DRB Application No.: 03-01648 (SBP)
Project Name: WEST MESA OPEN SPACE
Agent: Molzen Corbin & Associates

**DEVELOPMENT REVIEW BOARD
TRANSPORTATION DEVELOPMENT
Standard Comment Sheet**

DRB- 1002197 Item No. 15 Zone Atlas E-9

RE: Project # 1002197 03DRB-01648

CAB-101 1"=100' (1=2003/04/03)

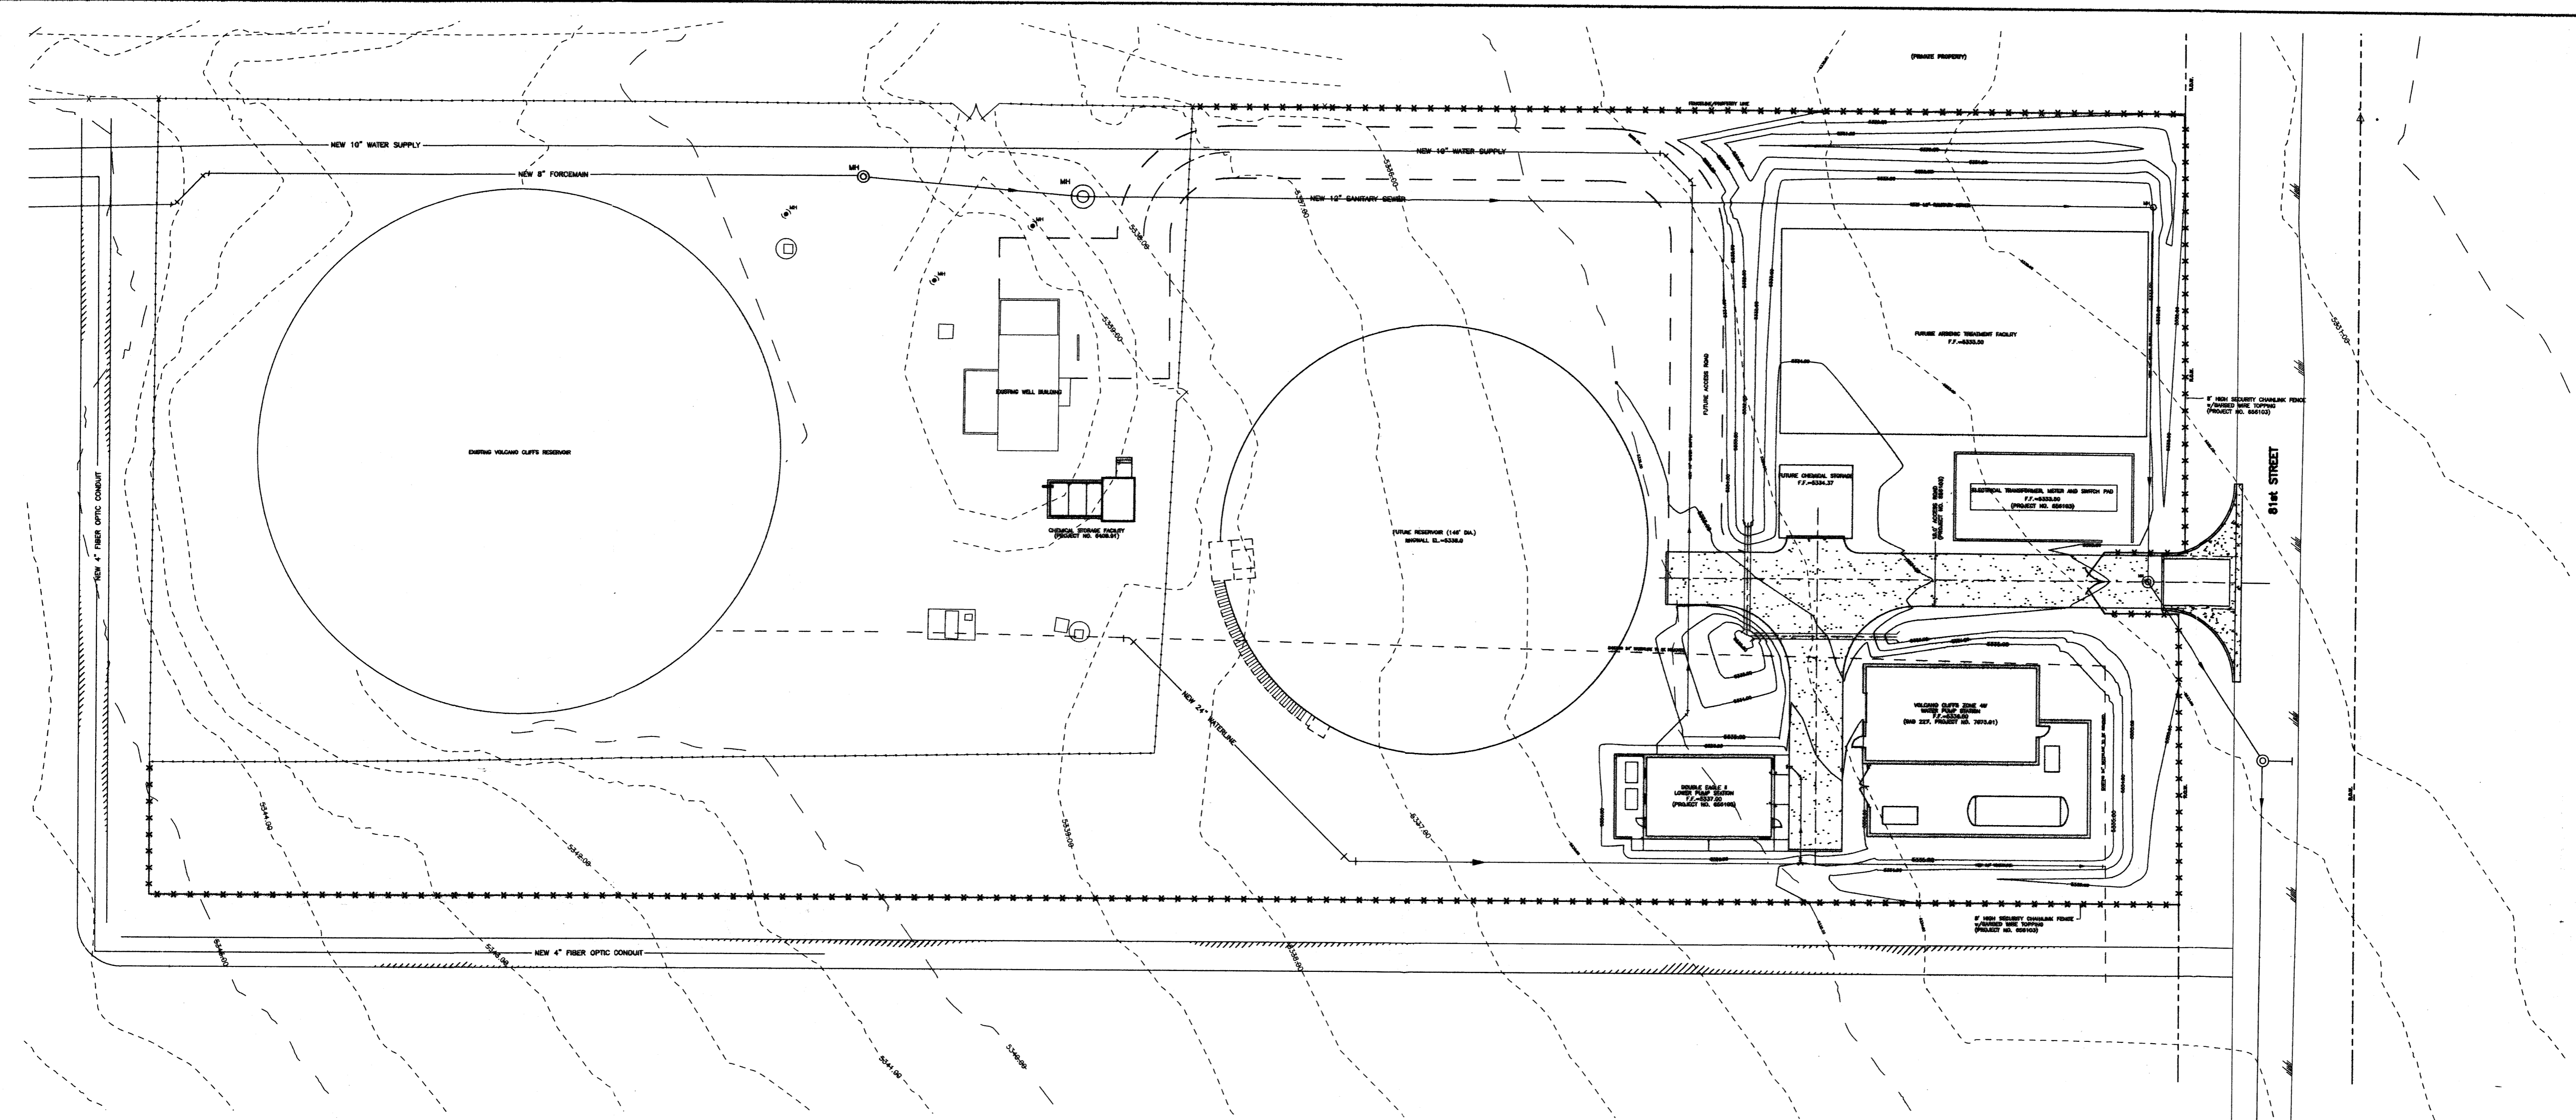
① NEED TO LOOK @ RADI w/ TYPES OF
DELIVERY VEHICLES

② WHAT IS 10' RECREATIONAL TRAIL?
